**Horsley Drive Business Park Stage 2 Mod1 (SSD-7664-Mod-1)
Response to Submissions**

Attachment 1

Based upon the Department's review of the information submitted with the modification, the Department considers further information is required to clarify matters and address inconsistencies within the documentation. In this regard the following additional information / clarifications are required to be provided:

Figure 1 Proposed Plan of Subdivision

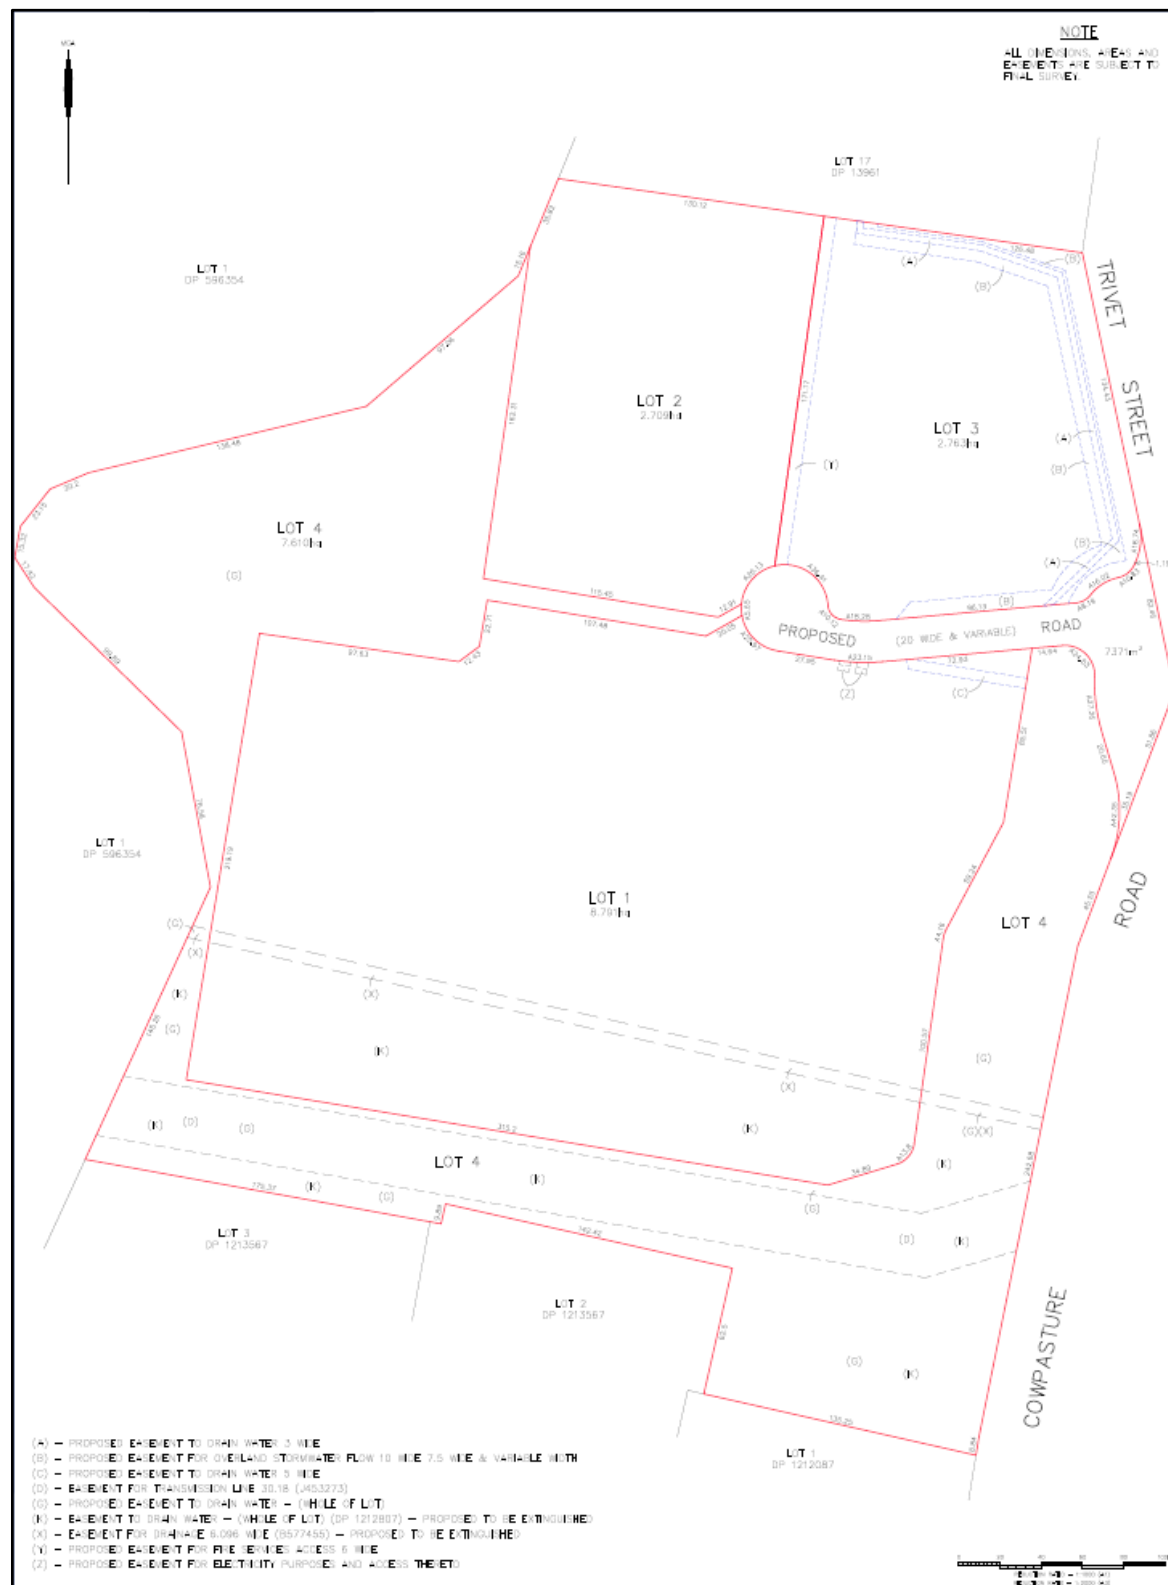
3. an amended site plan which clearly illustrates for example existing lot boundaries, topographic contours, lot sizes, building envelopes, easements, existing infrastructure.
4. confirm if lot consolidation is being sought under SSD 7664 MOD 1. If so, the amended site plan should reflect this and a plan of consolidation, provided.
